Stage 1 RSA - Road Safety Audit Addendum Response Report

1.1 This report results from receipt of a Stage 1 RSA Report, undertaken dated September 2017.

Organisation: Mayer Brown Limited

Date: 27 October 2017 [Rev P3]

drawing number	rev.
A/PHLITTLE-INT.1/TK-1	P6

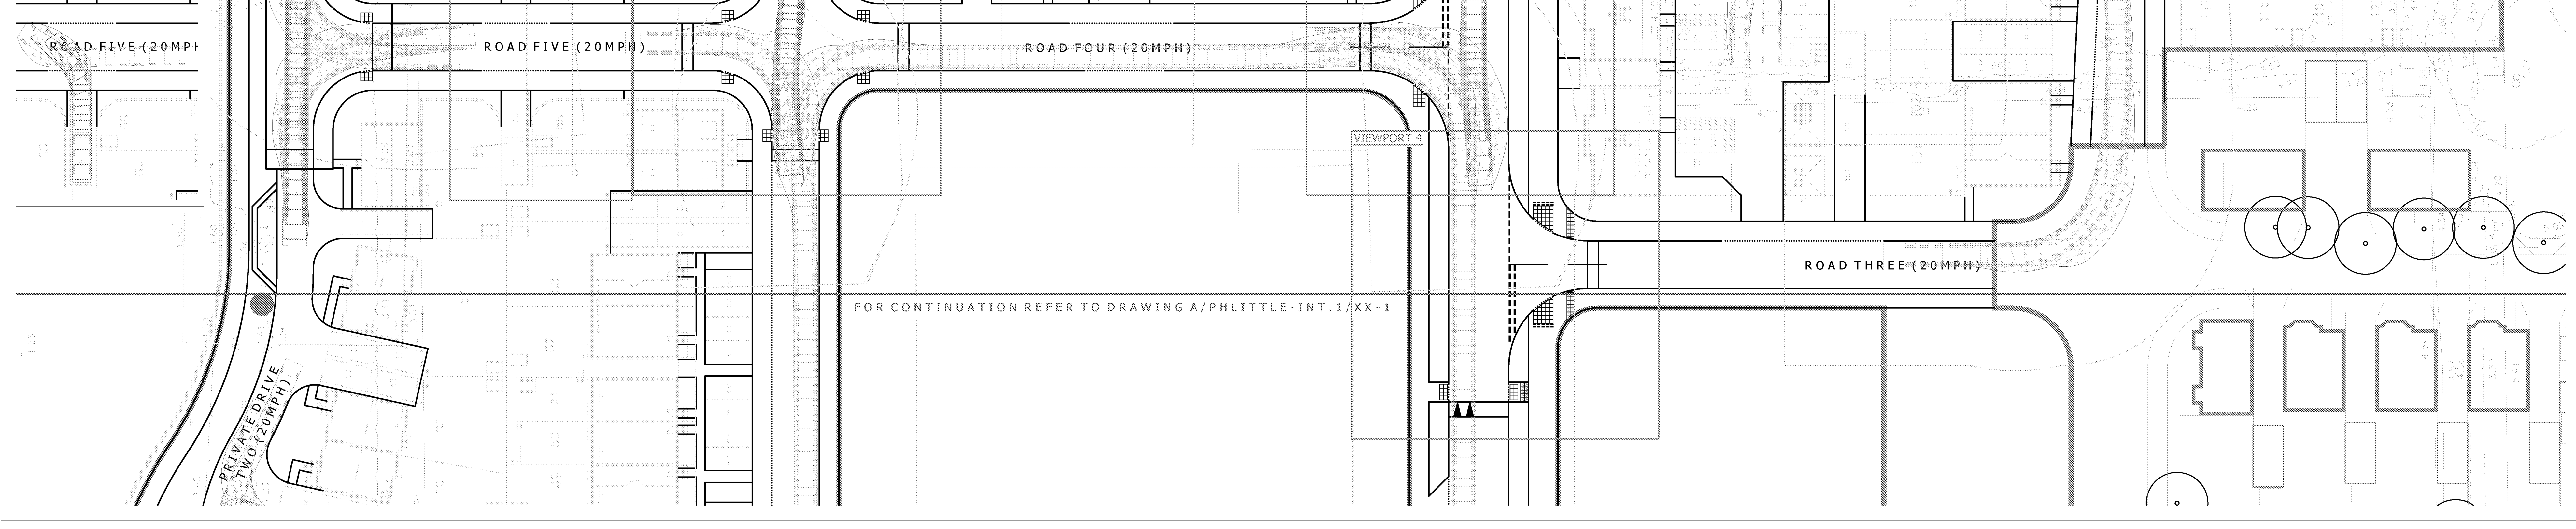
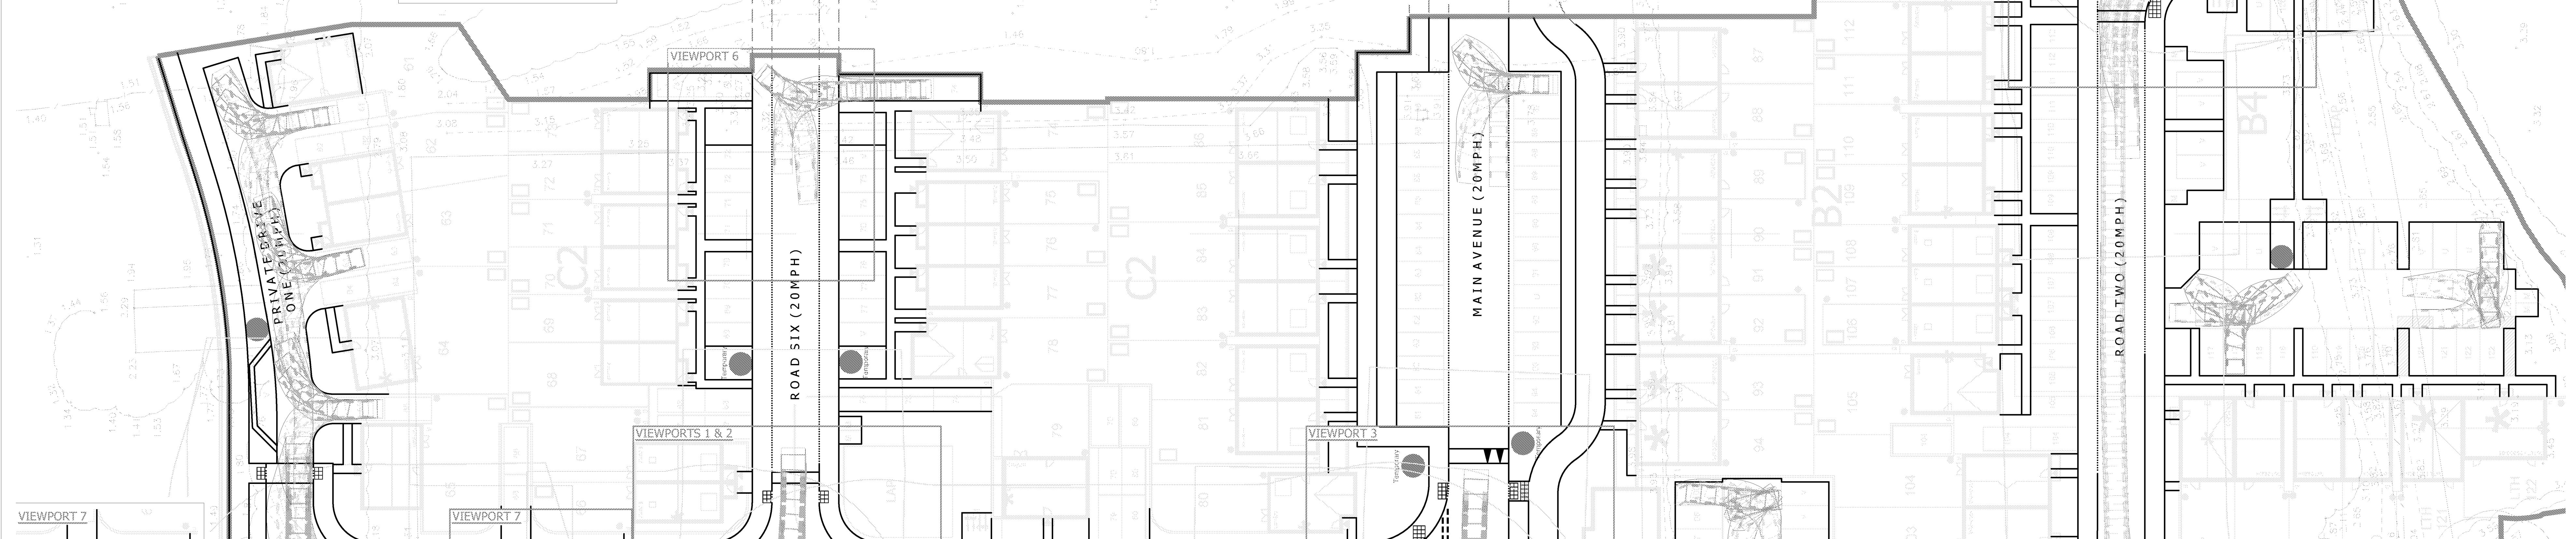
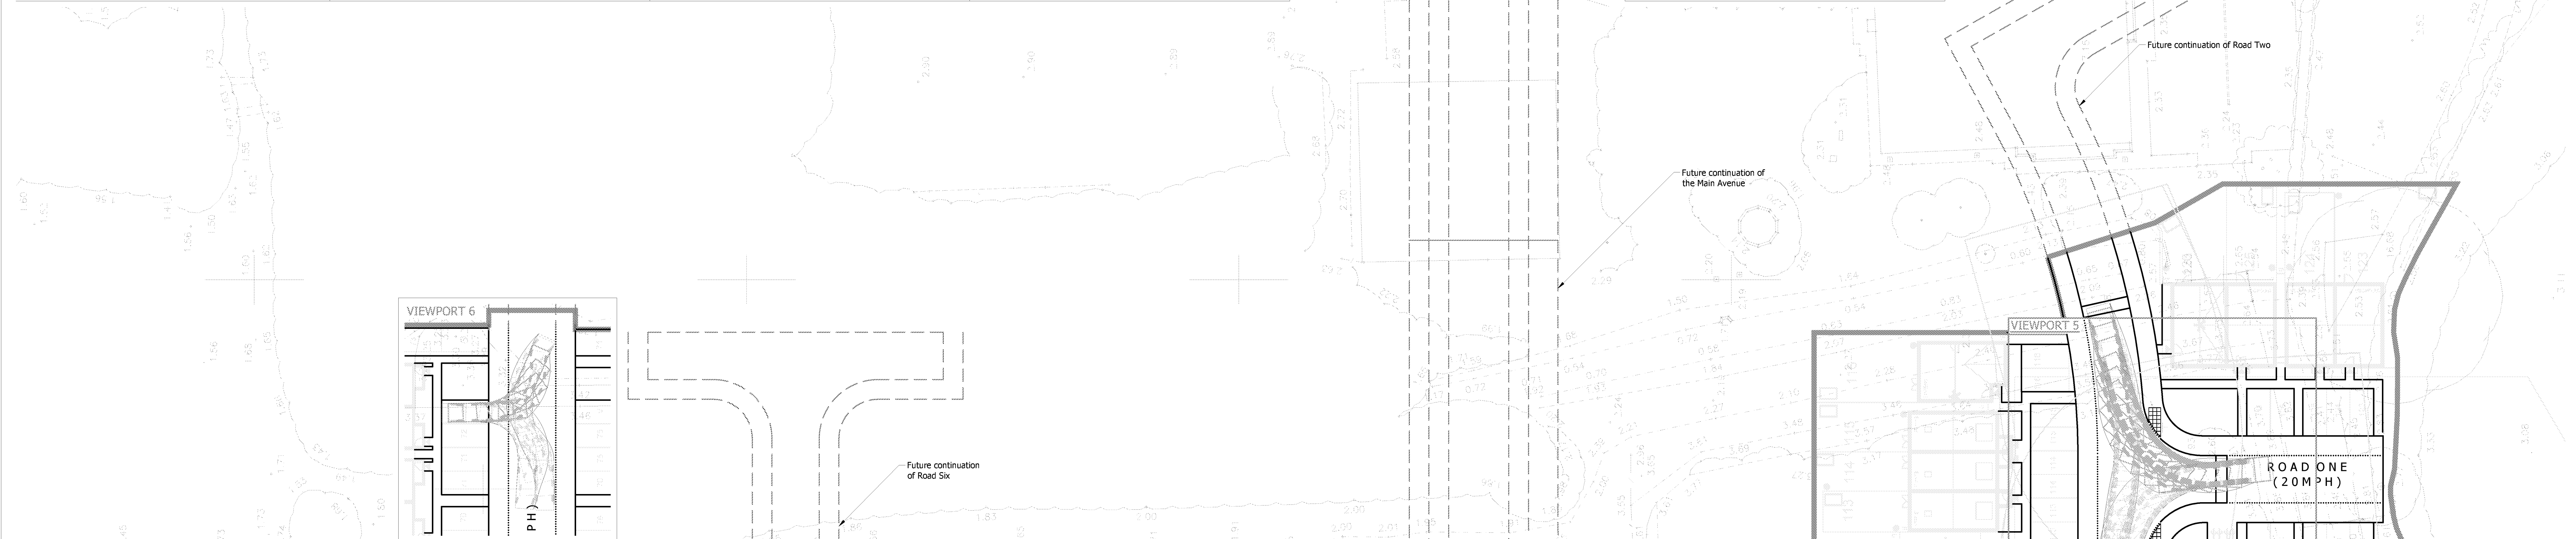
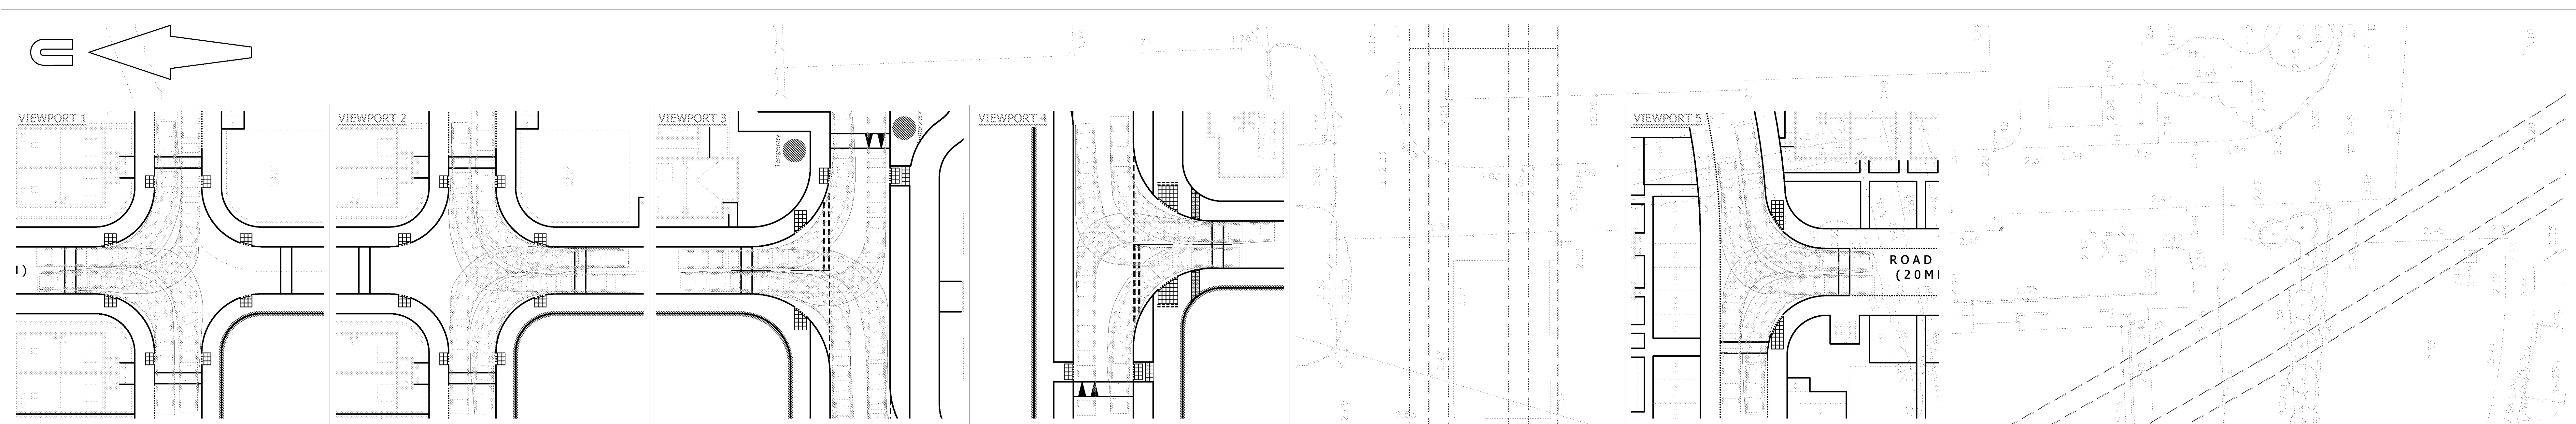
Item	Problem	Recommendation	Designer's Response
3.2	Location: General Summary: Potential obstruction to service vehicle manoeuvres The swept path analysis provided to the Audit Team indicates that a large refuse vehicle is able to service the site without excessive reversing manoeuvres or encroachment on the footway. However, many of these manoeuvres will be obstructed if on-street parking were to occur within the development. This could result in excessive reversing manoeuvres or encroachment on to the footway(s).	If on-street parking does occur within the extent of the swept paths then West Sussex County Council should consider implementing a traffic management order prohibiting vehicles from waiting "at any time" within the extents of the swept paths.	The development shall be provided with designated parking as agreed with the LPA and HA and as outlined in the Transport Statement. The Transport Statement reports (Para 4.14) that there will be ample parking capacity within the site. If on-street parking does occur within the extent of the swept paths then PHTV will liaise with West Sussex County Council to consider implementing waiting restrictions to prohibit vehicles from waiting within the extents of the swept paths.
